Planning Application No: 3/2026/0042

Proposal: Outline application for the proposed erection of two dwelling houses with access applied for.

Location: Land adjacent to Fernhill, Ribchester Road, Clayton Le Dale BB1 9EG

Having reviewed the documents submitted Lancashire County Council acting as the highway authority makes the following initial comments and requests further information.

0783 / 93 Drawing No 06

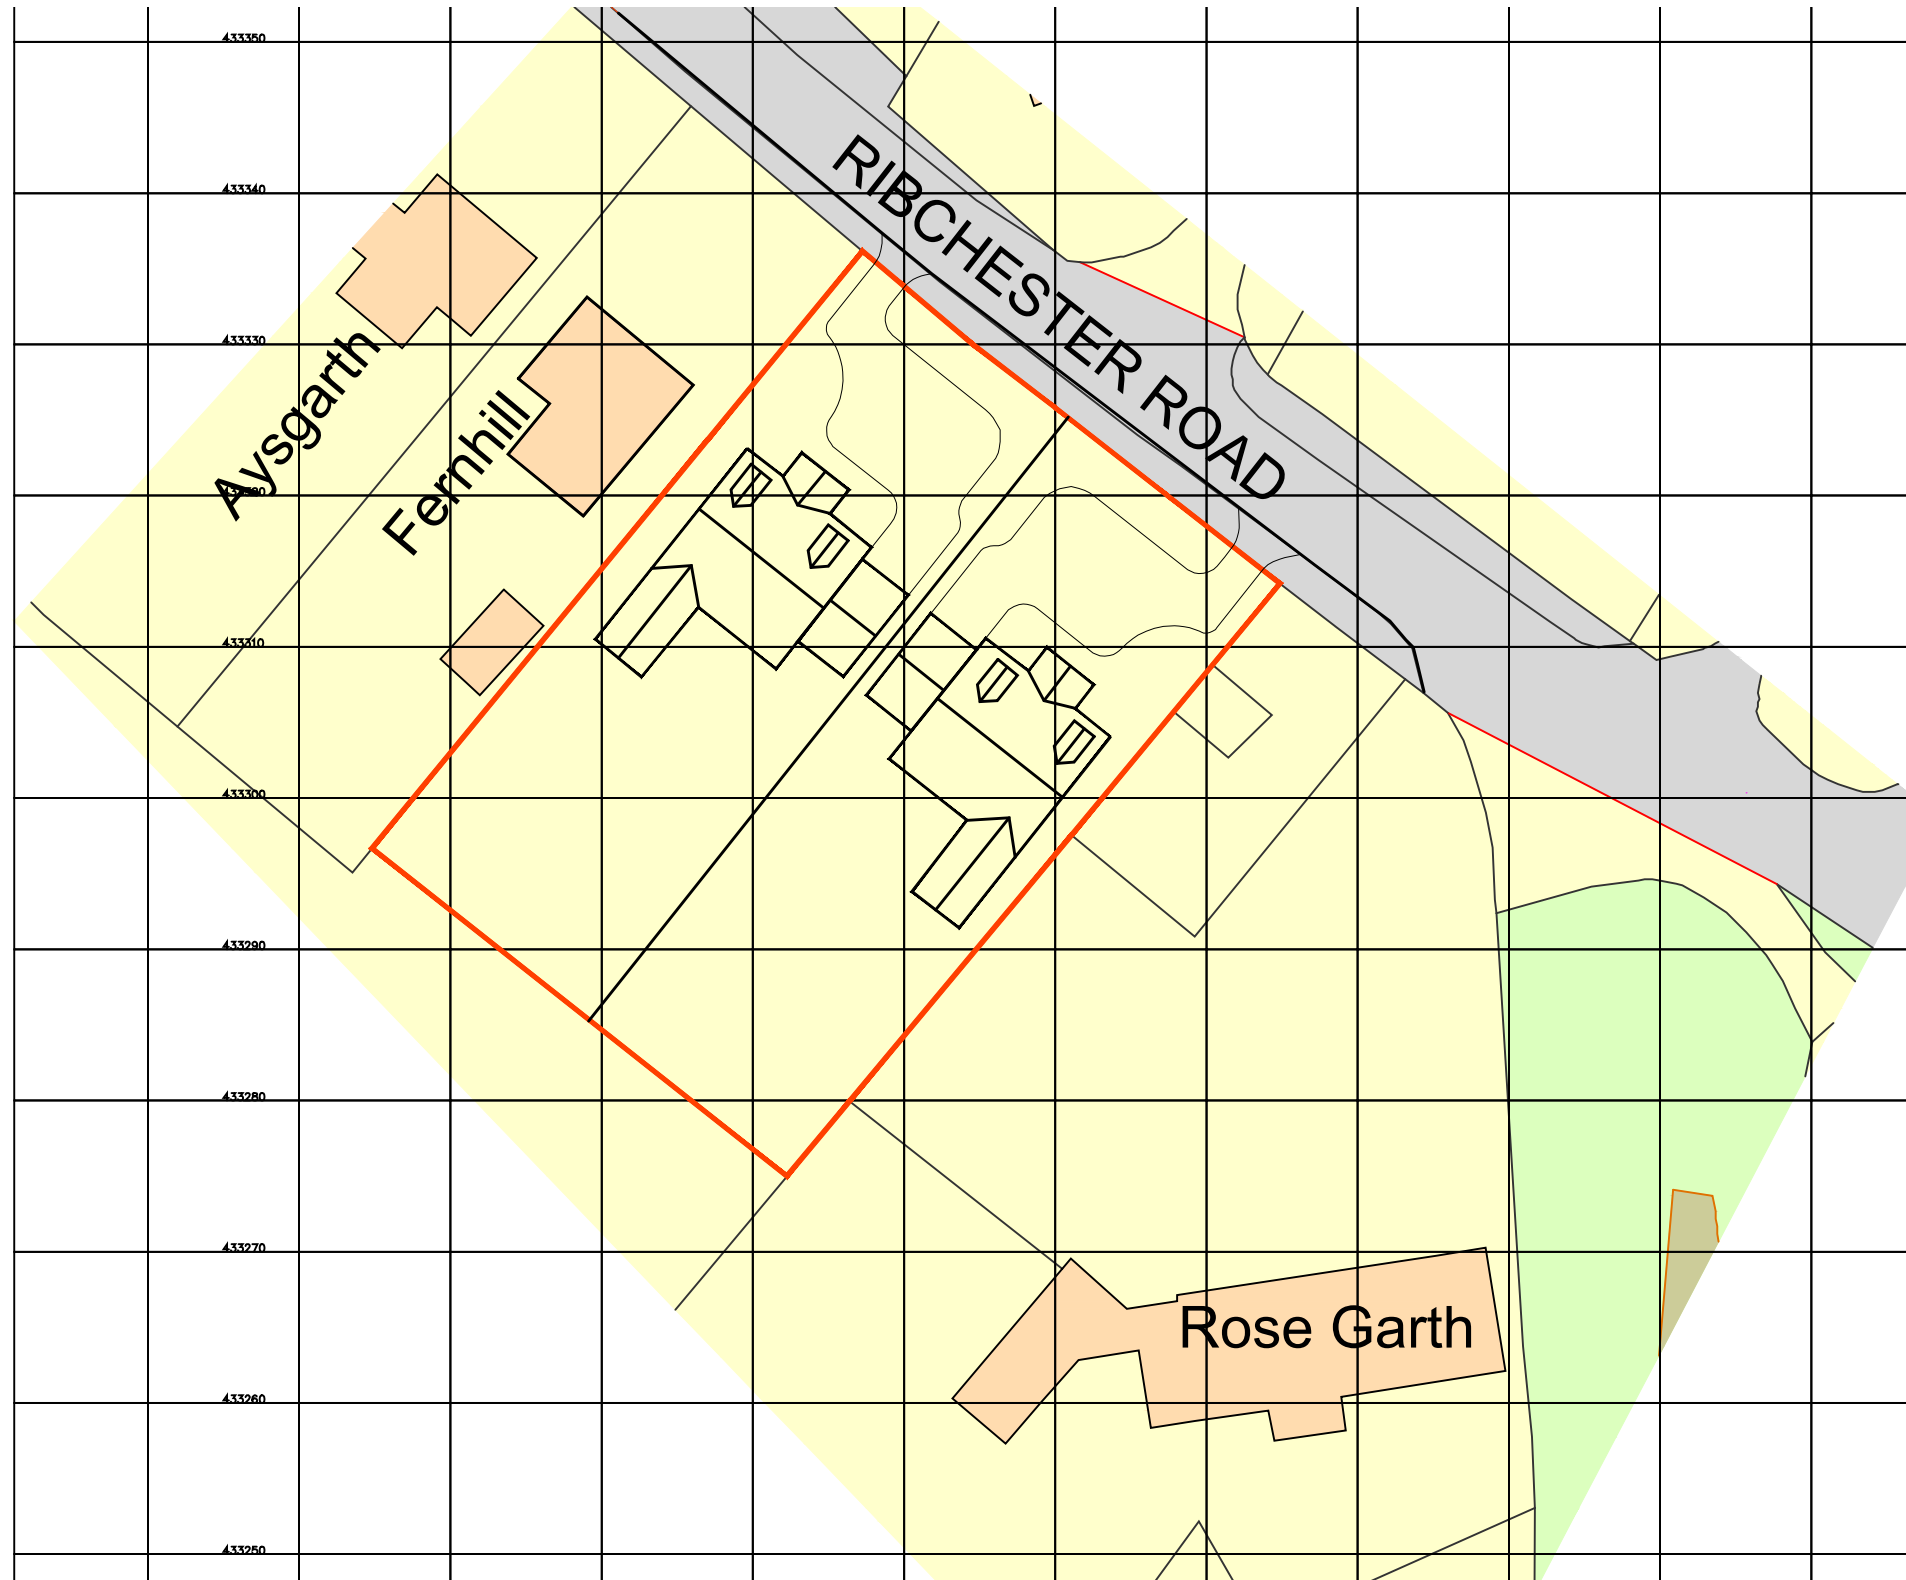
Two new vehicle access points are proposed from the site onto Ribchester Road. Revised site plans are required based on measurements taken on site and not on the OS layer. The Proposed Site Plans submitted (Drawings 06 and 11) show a footway/verge of up to 2m wide across the site frontage. The revised plans should show the correct width of the service verge, which is narrower, and also locations of highway gullies and street lighting columns across the site frontage and immediately adjacent.

No site section plans have been submitted to demonstrate how appropriate accesses will be constructed given the level differences between the carriageway on Ribchester Road

and the site, which slopes up from the road. Existing and proposed site level drawings should be submitted.

The accesses should also be constructed so that there is not a steep gradient to the driveways. The accesses would need to be surfaced in a bound material for at least 5m into the site from the back edge of the service verge. Surface water would also need to be collected across the front of the accesses and drained to suitable internal outfalls to prevent surface water from discharging onto the public highway network. Details of the surface water drainage should either be submitted prior to determination or will have to be controlled by condition.

The applicant has not submitted any visibility splay drawings. Based on the above criteria the highway considers that adequate visibility splays cannot be achieved, with splays from both access points being over third party land and hence out of their control. Unless and until adequate visibility splays have been demonstrated from the site, which may require the access points being re-located, the highway authority objects to the application.

The development would be accessed from Ribchester Road (B6245), which is a two-way, classified road subject to a maximum speed limit of 30mph. For a road with a speed limit of 30mph visibility splays of 43m in both directions from each access will be required. Visibility splays should be measured to the nearside carriageway edge on Ribchester Road and nothing over 0.9m in height above the carriageway level should be within the visibility splays. The visibility splays must be over land within the applicant's ownership and/or the publicly maintained highway network with no part of any splay over third party land.

If appropriately scaled drawings and plans are submitted which demonstrate that the necessary visibility splays can be achieved over land within the applicant's ownership and/or the highway network maintained at public expense then the highway authority will review its comments and may consider withdrawing its objection. The further information requested regarding the construction of the accesses also needs to be provided.
